Planning and Regulatory. G.Mansfield
Reference: PB2015/01261
Phone: 02 4974 2767

NOTIFICATION OF MODIFICATION REQUEST BULK LIQUIDS FACILITY GREENLEAF ROAD KOORAGANG

I refer to your email of 27 November, 2015 advising that Park Pty Ltd has submitted a request (07_0066 MOD 4) to further modify the project approval granted in 2008 for the marine fuel storage facility, biodiesel production facility, pipeline and associated infrastructure.

FIGURE 1.2

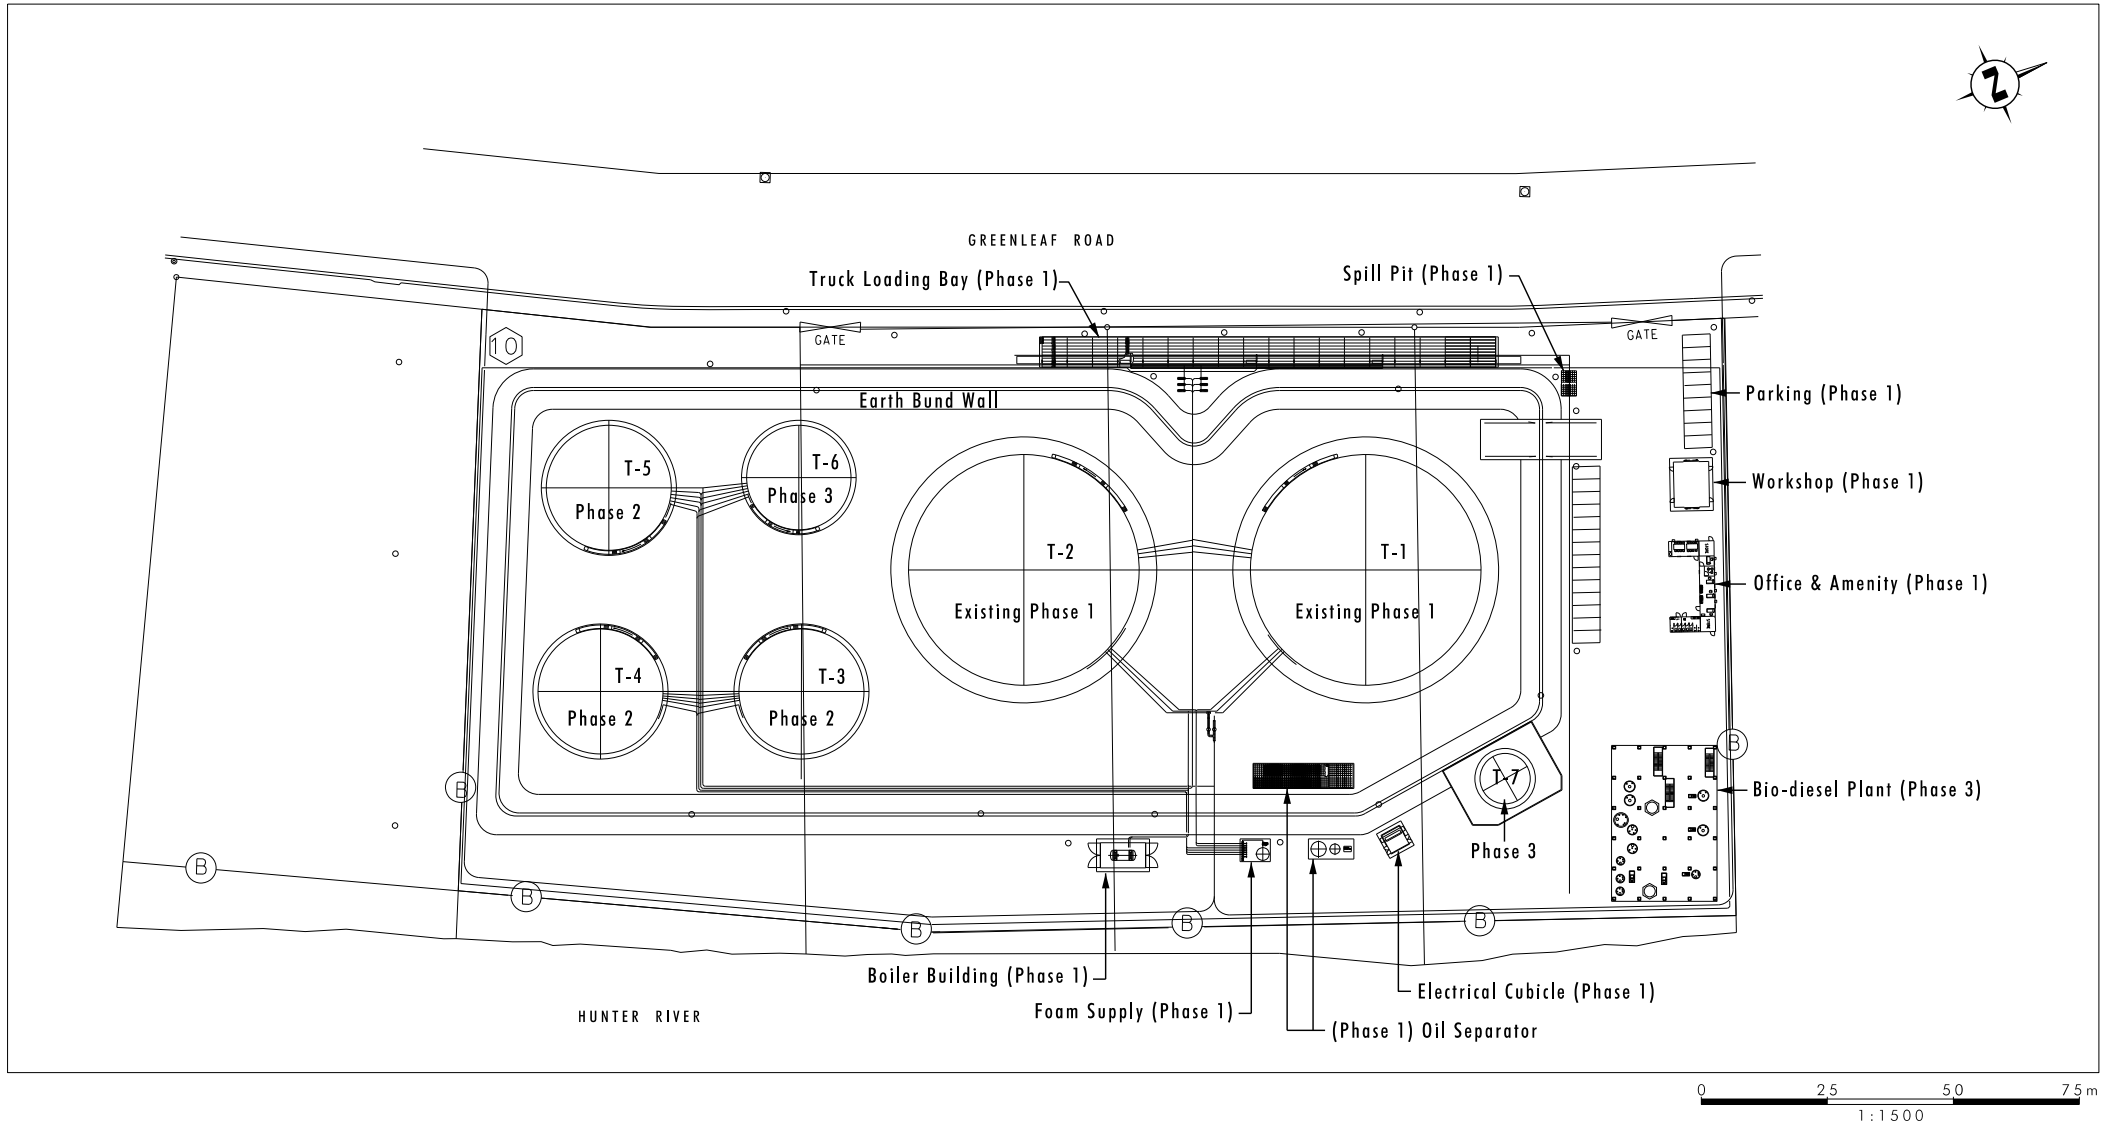
In comparing the details of the layout of the approved project as depicted in Figure 1.2 with the proposed site layout shown in Figure 2.1 of the Umwelt submission it is noted that several modifications have been undertaken to the approved project. Initially this caused some confusion because no explanation for these modifications is provided in the submitted documentation and a relevant modification approval could not be found on the Department's Major Project Register. However, I understand several modifications to the original layout were included in the approved Construction Certificate documentation and plans.

FIGURE 2.1

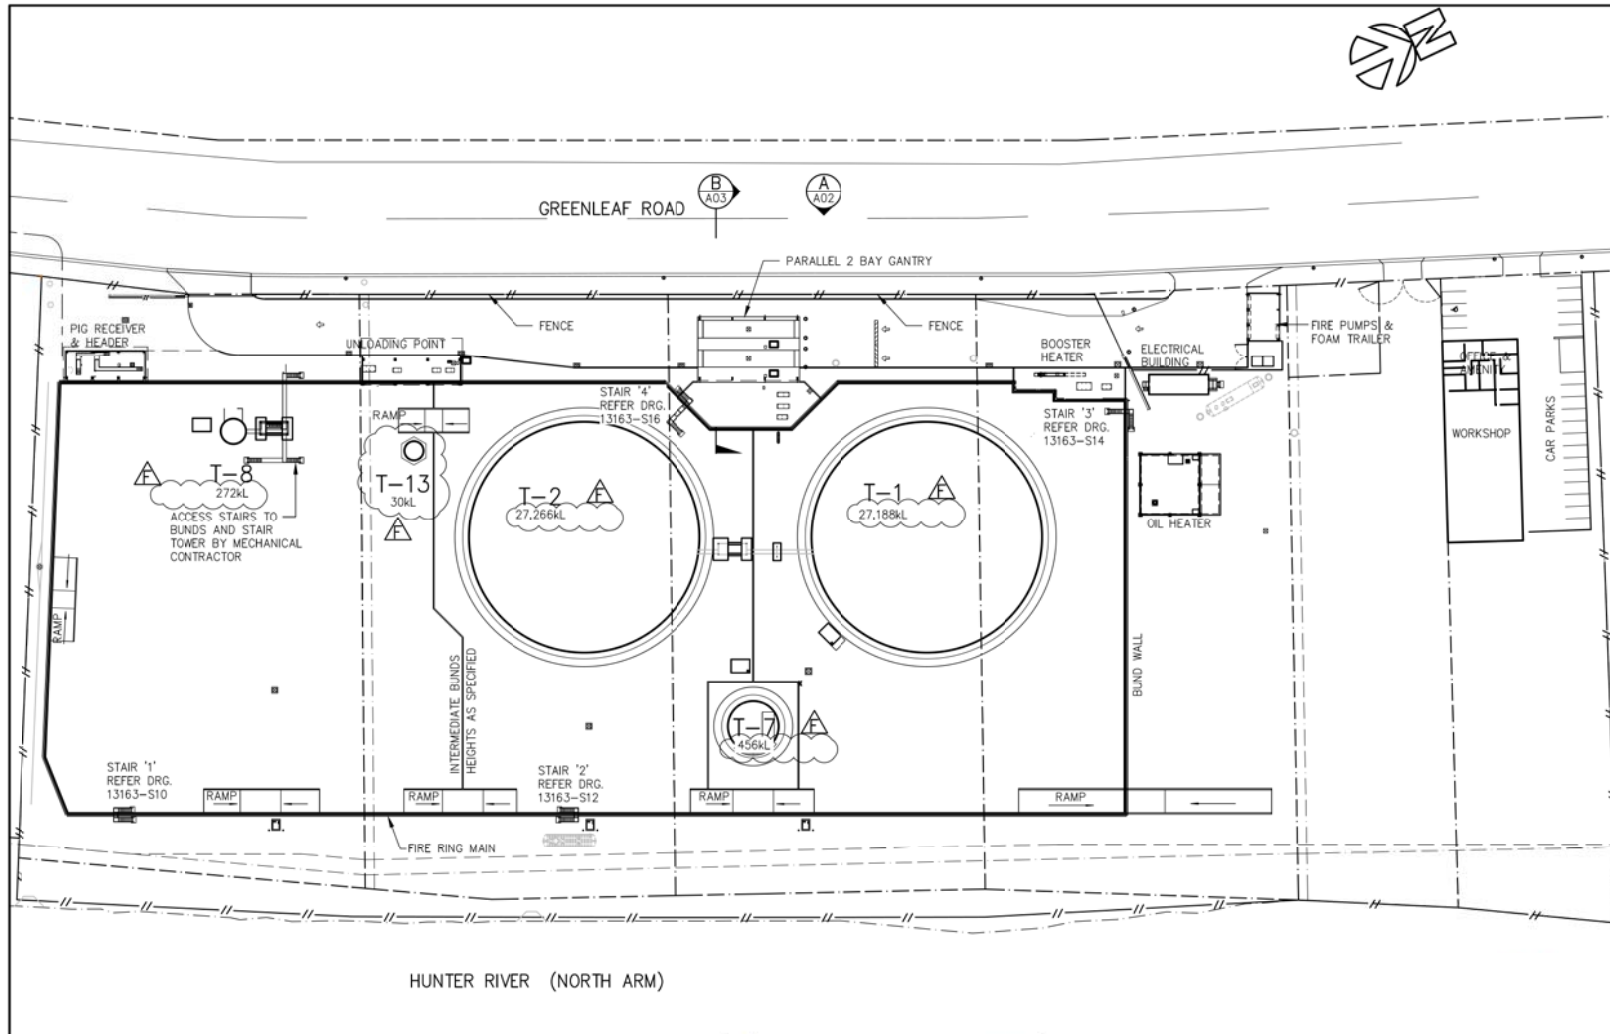
Furthermore, in regard to the building on Lot 3 Figure 2.1 of the Umwelt submission indicates the proposed uses as office and workshop, while Figures 2.3 and 2.4 refer to offices and warehouse. The original buildings on the approved project comprised a workshop, and an office and amenities.
